TfNSW reference: REN25/00075/002

**SSD-48225958 – Gundry Solar Farm – Response to Submissions - Goulburn Council**

Transport for NSW (TfNSW) is responding to the Gundry Solar Farm response to submissions (RtS) referred via the Major Projects Portal.

TITLE: SWEPT PATH ANALYSIS - SOUTHERN ROUTE - SLOANE STREET/BRAIDWOOD ROAD
AUSTROADS (2013) 19m PRIME MOVER AND SEMI-TRAILER

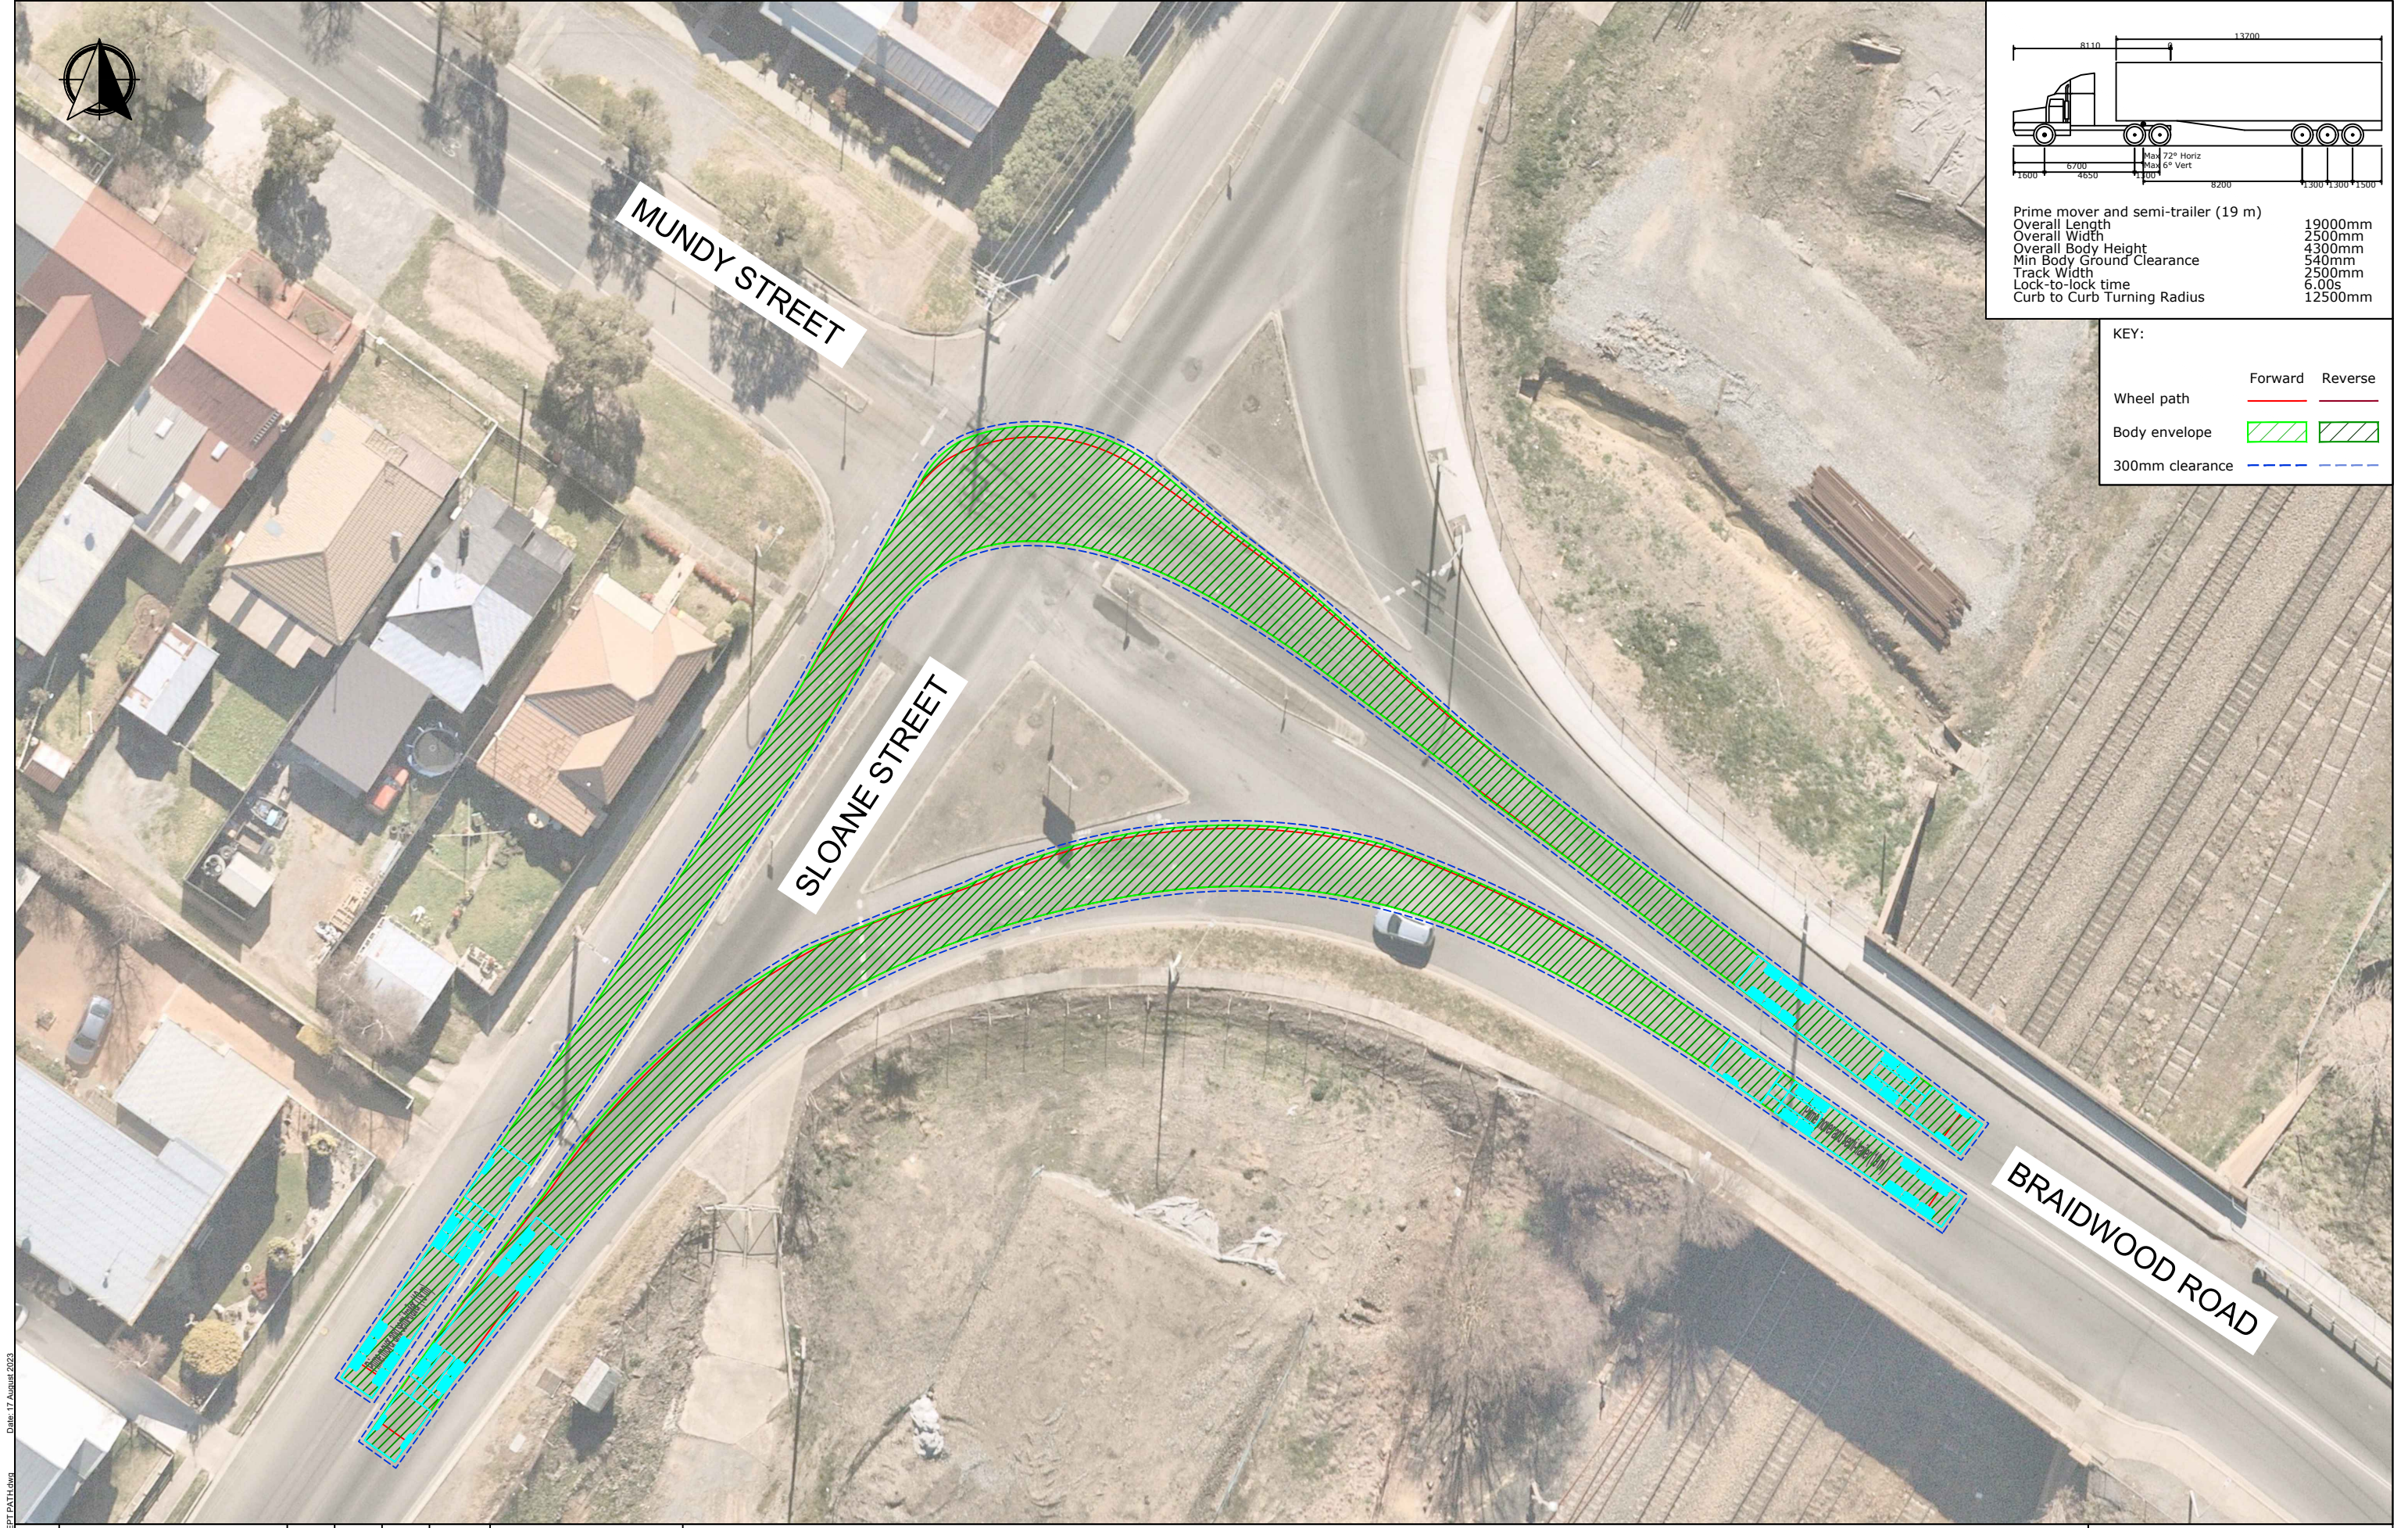
f) Show the project traffic added to each intersection that has been analysed in the TIA.	<p>same time as the Gundry construction project data. Proponent is to consider offsetting start times as a mitigation measure to reducing impacts to the urban roads around Goulburn</p> <p>f- OPEN – Proponent is to confirm and clearly label the raw traffic data for the intersection of Bungonia / Braidwood and Braidwood / Sloane Street that has been used in the intersection analysis.</p>

3.	<p>The origin, destination and routes are to be shown for:</p> <p>a) Employee and contractor light traffic.                  b) Shuttle buses.                  c) Heavy vehicle traffic.                  d) OSOM vehicle traffic.                  e) OSOM high risk loads.</p>	<p>PARTIALLY ADDRESSED – <b><u>Pending electronic SIDRA files being provided:</u></b> TfNSW notes that turning volumes and routes for light vehicles/heavy vehicles/shuttle buses should be focused to reduce the impact on the state road network, particularly on the intersections of Braidwood / Sloane Street and along Braidwood Road.</p>
